CITY OF PORTLAND, MAINE

March 4th, 2013

Project Name: **Old Barn Estates 16 Lot Subdivision**
Project ID: 2012-584; CBL: 414-A-4 (and part within Town of Falmouth)
Address: 1062 Ocean Avenue (Ledgewood Drive)
Applicant: Tim O'Donovan, TPO Properties LLC
Planner: Jean Fraser

TO: Jean Fraser, Planner
FROM: David Senus, P.E.
DATE: February 20, 2013
RE: Final Level III Site Plan Application Response to Comments – Old Barn Estates

PROJ. NO. \_\_\_\_\_  
 DWG. NO. \_\_\_\_\_  
 REV. \_\_\_\_\_  
**S-101** H

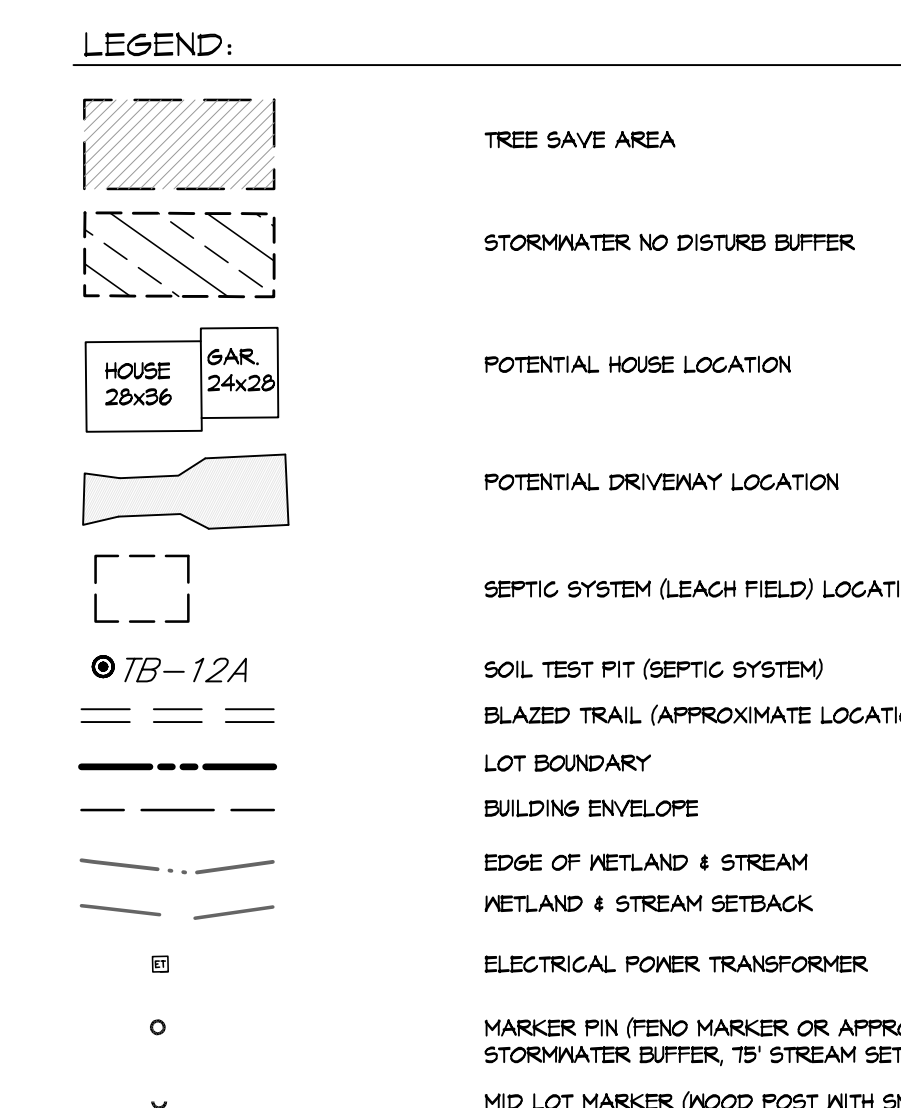
4. *Comment: The Applicant notes that "Deed restrictions and covenants will be created for all buffers and will be provided for review". This language has not been received/reviewed with the current submittal, and will be reviewed upon receipt.*

Applicant Response: Plan S-101 note 17 addresses the limitations of disturbance in the stormwater buffer areas which will be linked to the deed through Note 1 on the attached Deed Restriction PDF.

Additional language should be incorporated into the applicable deeds following the guidance outlined in the MaineDEP BMP Technical Design Manual, Volume III, Appendix D, "Templates for Deed Restrictions & Conservation Easements". Final deed restriction language should be submitted to the City for review as a Condition of Approval.

5. *Comment: Sheet S-101, Note 15 states that "Tree save areas and stormwater buffer areas shall be identified on the ground with capped rebar pins and signage as shown on Plan C-101"; however, C-101 does not specifically call out the rebar pins or signage.*

Applicant Response: Tree save and stormwater buffer areas are now identified on Plan C-101 showing location of rebar pins and signage. Also see note #15.

Although there appear to be symbols identifying the rebar pins and signage on C-101, these symbols are not identified within the plan legend or specifically called out on the plan. A callout for the pin and sign symbol should be added to C-101 (refer to the callouts used on S-101).
